PLAN CHECK: D21LA06805

Project: 1921 Bellamah Ave NW
DRB Project Number: PR-2022-007155 / SI-2022-02196 – SITE PLAN

Subject: DRB Revision 2
Date: 12.16.2022

1921 BELLAMAH AVE NW ALBUQUERQUE, NM	DRAWN BY pm/sb
	SITE PLAN FOR BUILDING PERMIT	DATE 12-21-22
	5571 MIDWAY PARK PL NE ALBUQUERQUE, NEW MEXICO 87109 (505) 858-3100 www.tierrawestllc.com	DRAWING
		SHEET # SP-1
RONALD R. BOHANNAN P.E. #7868		JOB # 2022047

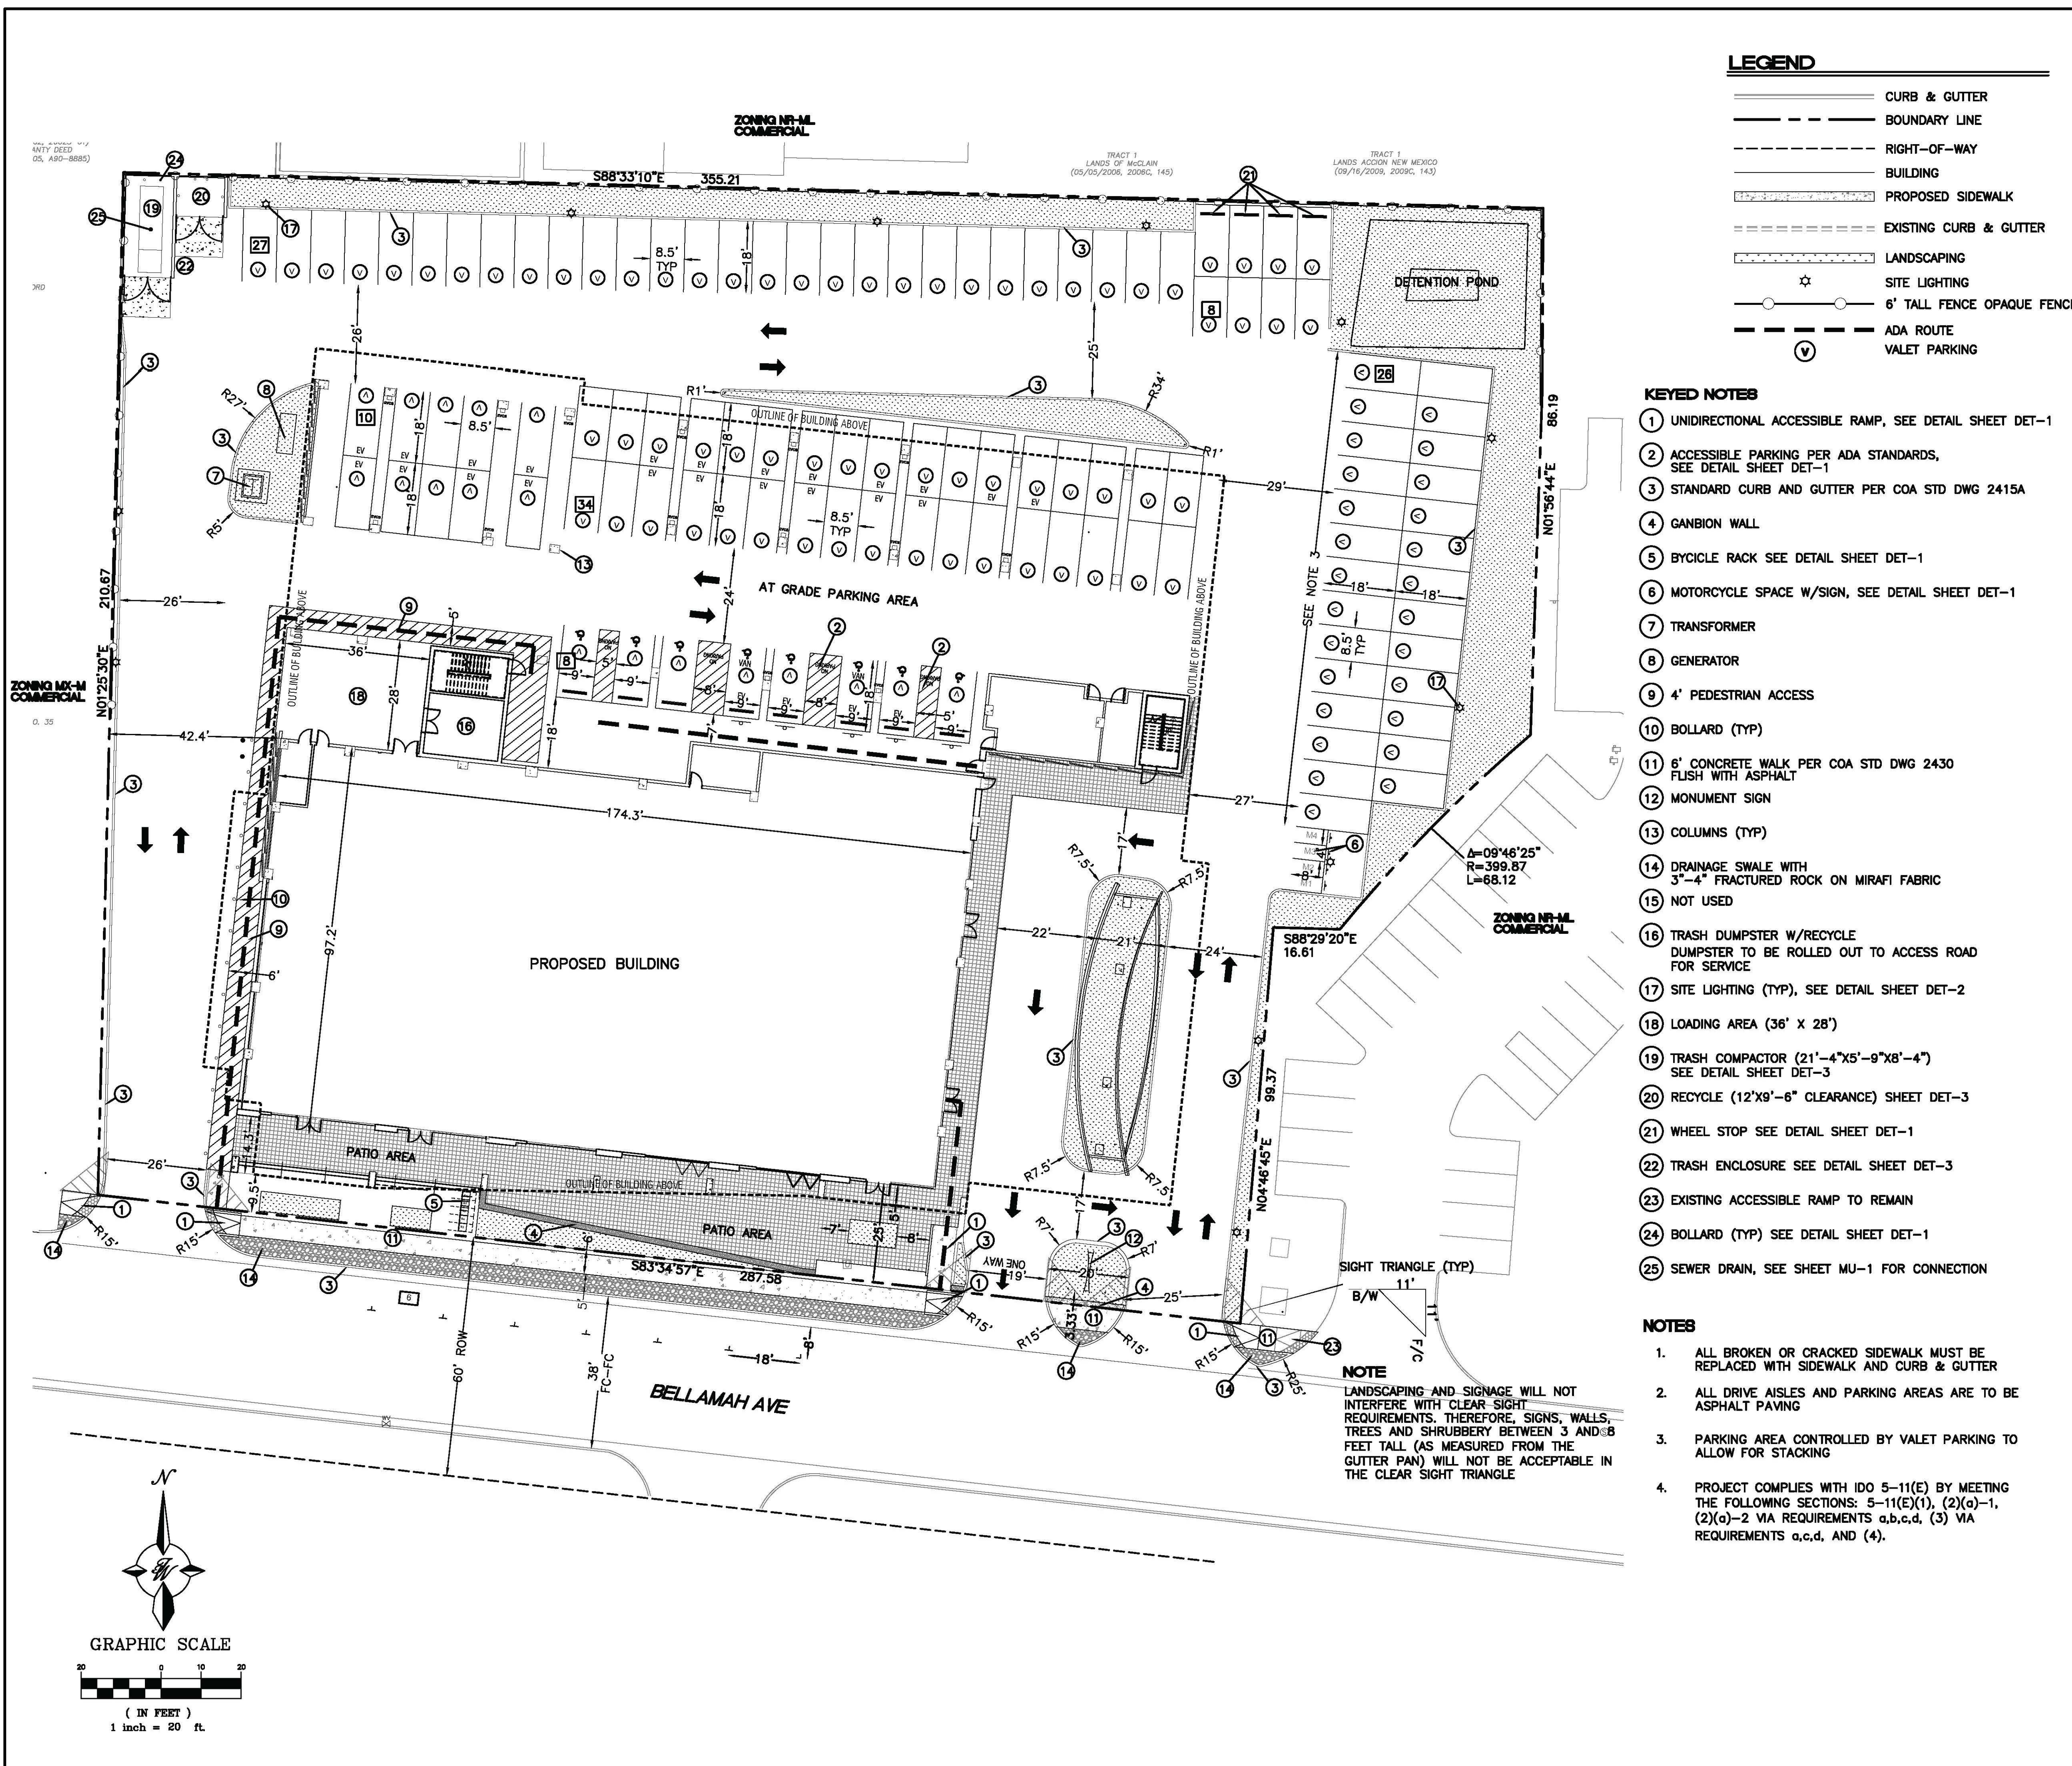
NO.	Comment	OU response	Location of correction
1	Property is apparently zoned MX-H through a recent zone change not yet reflected in our AGIS records.	No Response Needed	
2	2.Lighting must meet requirements of IDO 5-8 Outdoor and Site Lighting. For a mixed-use zone, light poles are limited to 20 ft height, as per IDO 5-8(D)(3), Table 5-8-1. Building mounted fixtures must be mounted no more than 15 ft above grade, as per IDO 5-8(D)(4).	19'-7" high light poles. check building mounted fixtures. Building lighting to not to exceed 15' above grade	DET-2 (page 85)
3	Signs must meet requirements of IDO 5-12 and Table 5-12-2. Monument sign must be set back 3 feet from property line – please indicate distance from property line on Site Plan. Tenant and other Wall signs must meet maximum percent of façade requirements, which is 15% for the MX-H zone, as per Table 5-12-2. Signs to be submitted under separate permit, but will need copy of Site Plan and measurements, accordingly, to show they are meeting the size and percent of facade standards.	Additional dimension added Signage calculation shown in elevation sheet.	SP-1 (page 83) D-A.30.01 D-A.30.02 (page 88/89)

6	IDO 4-3(B)(8) Use Specific Standards for Multi-family: Follow requirements in subsections (b) thru (d). Follow Use Specific Standards for the Commercial Use once identified.	The proposed project will not be for multi-family dwelling	
7	IDO 5-3(D)(2)(b) Sidewalks in Mixed Use Development: Reference DPM 7.2.29 for Sidewalk/landscape buffer widths. Bellamah is a Collector, Outside of a Center. Six foot wide sidewalks with a 5-6 foot landscape buffer zone is required. Please identify when the current sidewalk and landscape buffers were built and the proposed dimensions on your site plan.	Sidewalk dimensions added for 5' landscape buffer w/ 6' wide sidewalk	SP-1 (page 83)
8	IDO 5-3(D)(3) On-site Pedestrian Connections: Please confirm compliance. Provide required walkways and comply with shading of walkways. See Table 5-3-1 for required walkways adjacent to the street-facing facade for buildings >90,000 s.f., minimum walkway width is 15 feet.	The walkways is greater than 15' width to front entrance and less than 25' in length. We have overhang greater than 5' at entrance.	SP-1 (page 83)

14	IDO 5-6(D): Street Frontage Landscaping: One tree per 35 feet of building frontage is required or 5 trees; 7 trees are provided (5 existing and 2 new).	Informational comments No action on plans.	
15	IDO 5-6(E) Edge Buffer Landscaping: The parcel is abutting other parcels zoned Mixed-Use or NR-LM. The parcel is surrounded by other parcels designated as Areas of Change. No edge buffering is required.	Informational comments No action on plans.	
16	5-6 (F)(1)(a) Parking Location and Design: 15% of the Parking Lot Area shall be landscaped or 6,656 SF is required; plan exceeds this requirement with 7,354 SF.	Informational comments No action on plans.	
17	No parking space shall be further than 100 feet from a tree. And one tree for every 10 stalls is required or 12 trees total; 14 trees are provided.	Informational comments No action on plans.	
18	<p>IDO 5-6(F)(1) Parking Lot Edges: Confirm Compliance. (i) Check compliance with this provision: Landscape buffers are required in the following locations, with minimum widths and design requirements as specified below. 2. Side and Rear Lot Edges Where no side or rear lot line buffer is required by Subsection 14-16-5-6(E) above, the following standards apply where the side or rear lot line abuts a public street: a. General Any parking lot located within 20 feet of a side or rear lot line shall be screened by a landscaped strip at least 6 feet wide containing at least 2 trees and 6 shrubs per 25 feet of the parking lot edge closest to the lot line, or by other means that the Planning Director determines provides equal or better screening of the headlights of parked vehicles.</p>	Fencing around the parking to be opaque. Notes revised.	SP-1 (page 83)

--Native and drought tolerant landscaped area., yet they are not required. --Cantilevered floors to provide self-shading and thermal regulating function. Perforated metal panel screens provide shading without sacrificing views of daylighting. --An L-shaped building geometry oriented to provide views toward the Sandias and a pool and amenity deck on the second floor. --A roof top deck with consideration of various methods of shading.		
20	IDO 5-11(E) Building Design Mixed Use. Provide a project letter showing compliance with 5-11(E) requirements, including Sawmill COP requirements IDO 3-4(M)(5) noted above or use site plan notes to show confirm compliance.	This section of IDO code will be addressed at DRB hearing.	
21	Please note the following IDO Sections (review pending): 5-7: Walls. Development requires separate permitting. Height per table 5-7-1 and Multi-Family exceptions per 5-7-D-3. 5-8 Outdoor and Site Lighting requirements. Include lighting information in Site Plan submittal. 5-12 Signs. Signage per Mixed Use and signage type. Reference table 5-12-2.	5-7: Noted 5-8: Additional lighting notes added to site plan and lamp detail sheet. 5-12: Noted	SP-1 (page 83) DET-2 (page 85)

LANDSCAPE PLAN

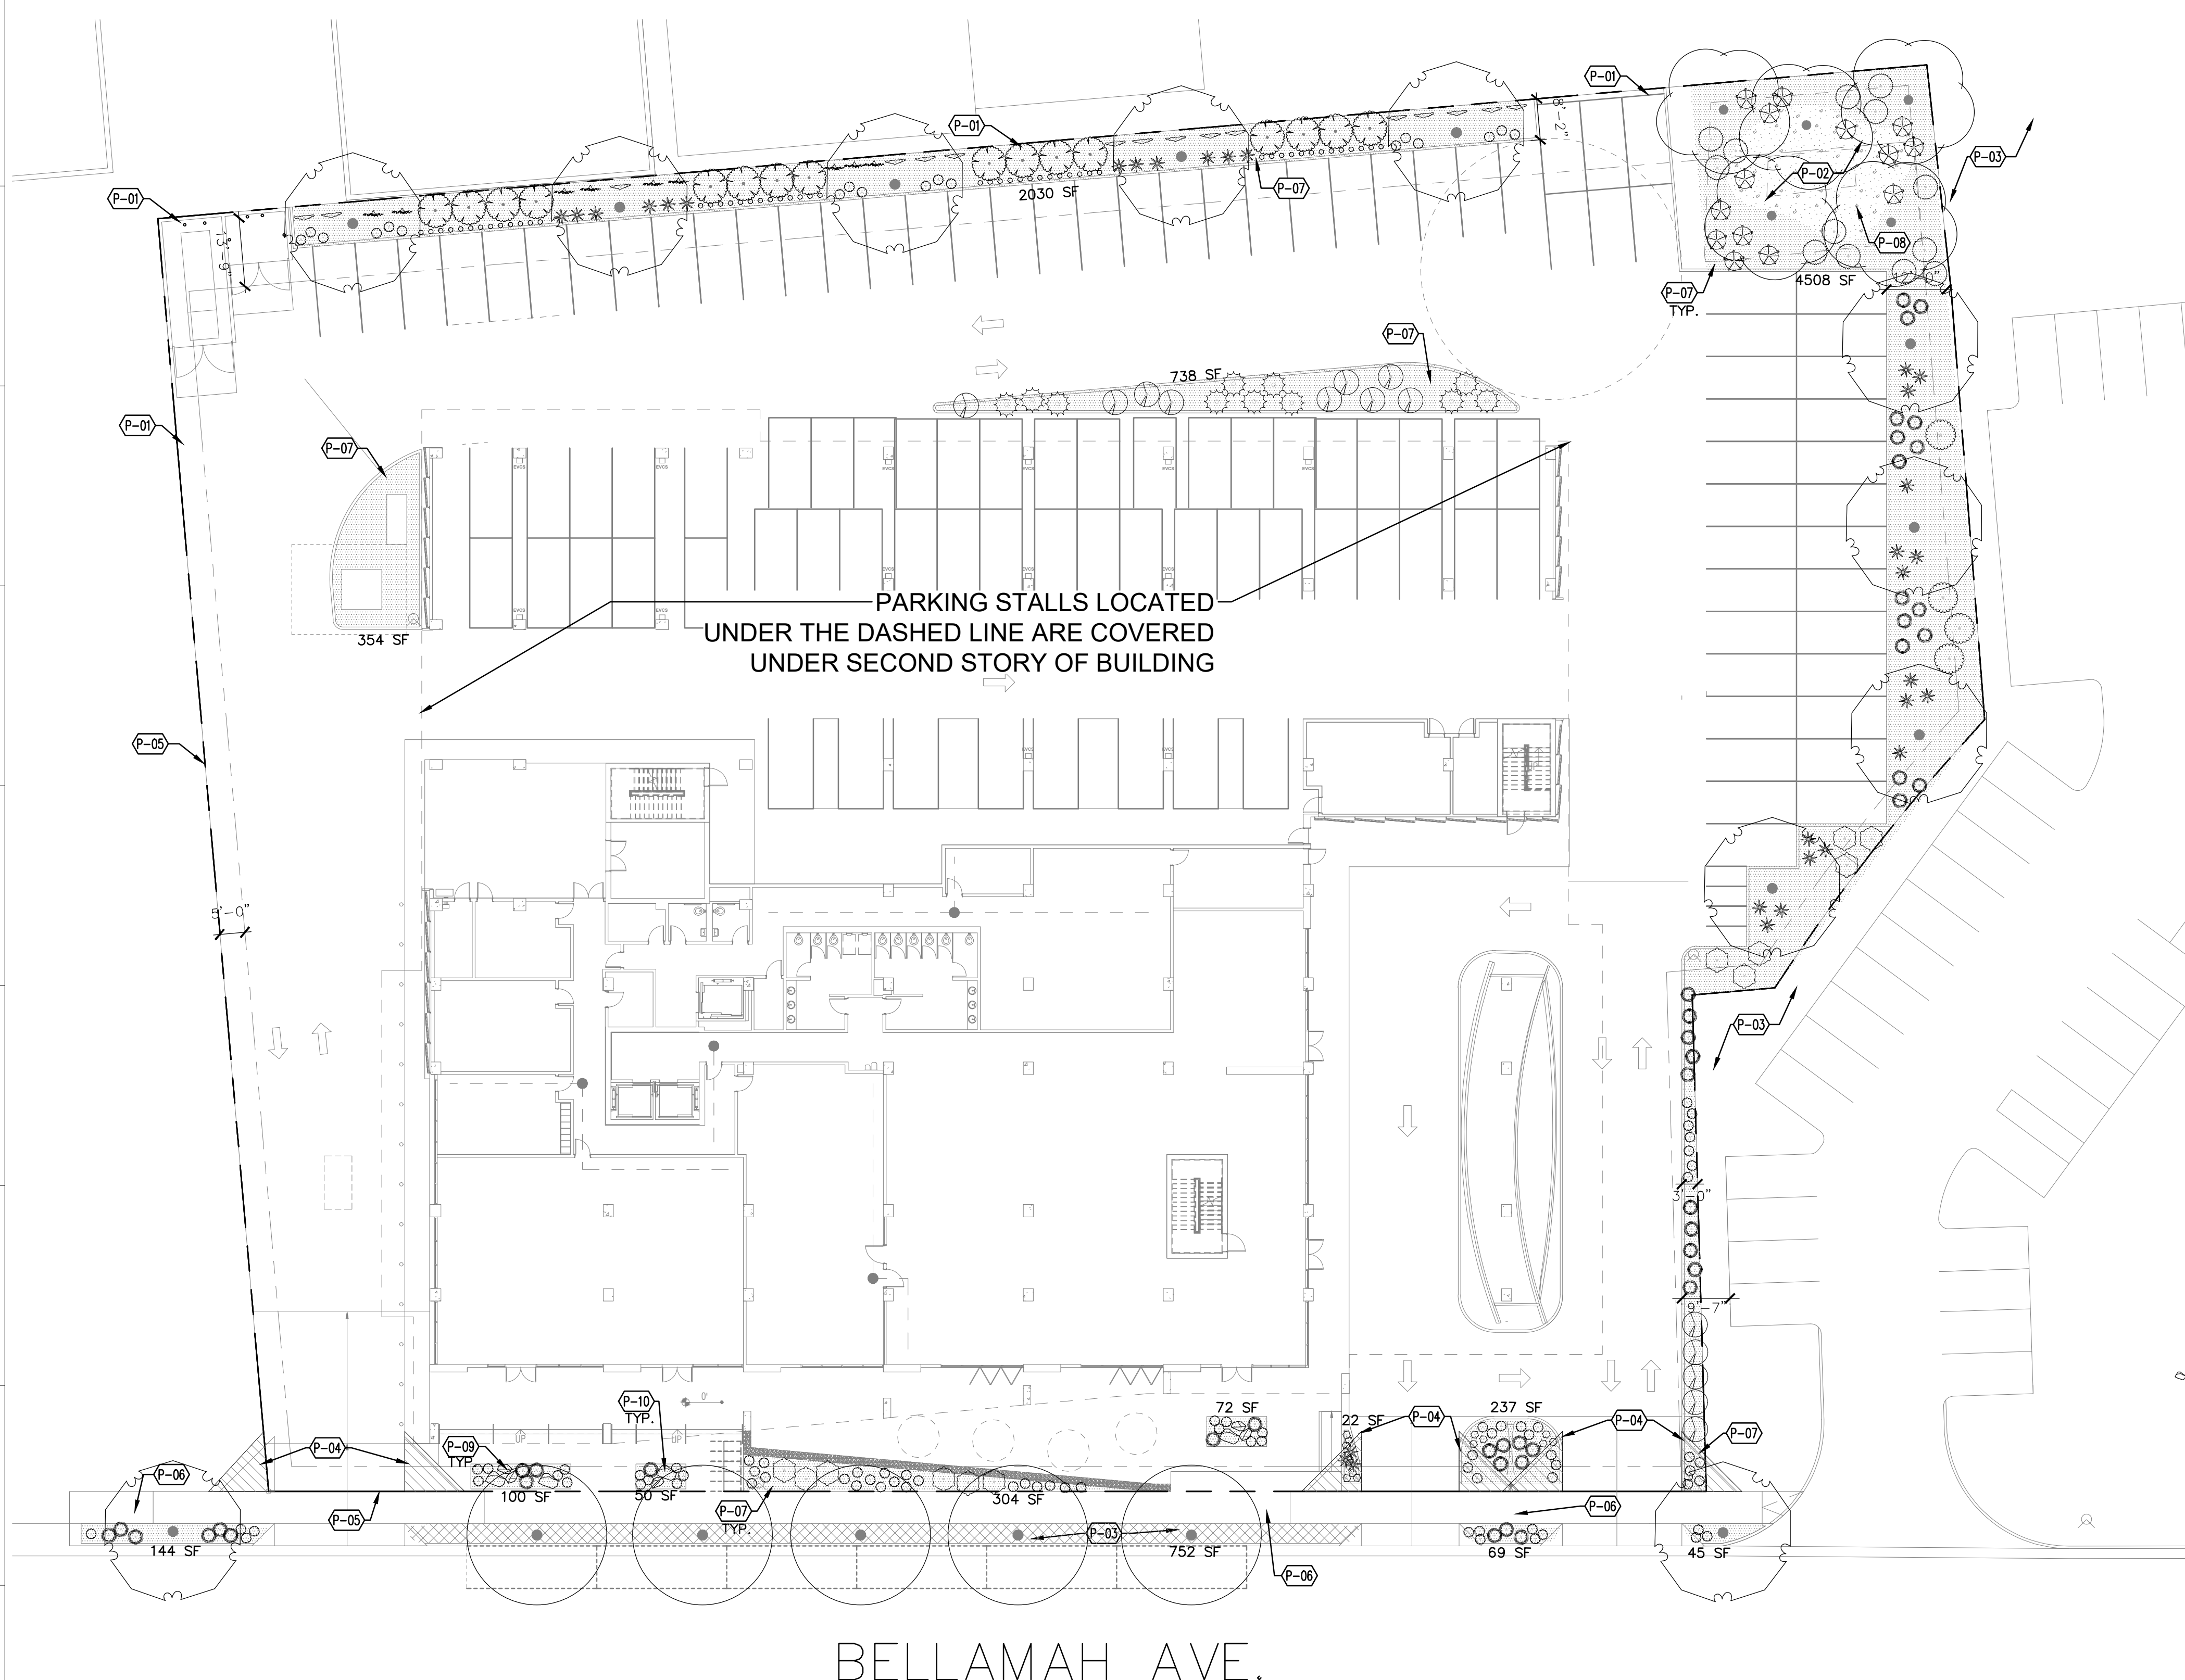
NO.	Comment	MRWMLA response	Location of correction
1	Cypress are listed in the City of Albuquerque Pollen Control Ordinance City of Albuquerque Bill Template 16th Council (cabq.gov); and Restricted Trees for Pollen Control – City of Albuquerque (cabq.gov)) - please substitute another tree for Italian Cypress.	We have substituted the Italian Cypress for the Blue Point Juniper.	LP101 (page 78)
2	IDO 5-6(C)(5)(e) states “Organic mulch is required as ground cover under trees within a 5- foot radius around the tree trunk, but not directly against the trunk. In these areas, weed barrier fabric is prohibited.” Please note this in the tree planting detail.	We have added the 5’ radius of organic mulch around the tree and it will be located under the rock mulch. See General Planting Notes 08 and	LP101 LP501 (page 78/79)

15/LP101 and Tree Planting Detail A1/LP501.	
--	--	--	--
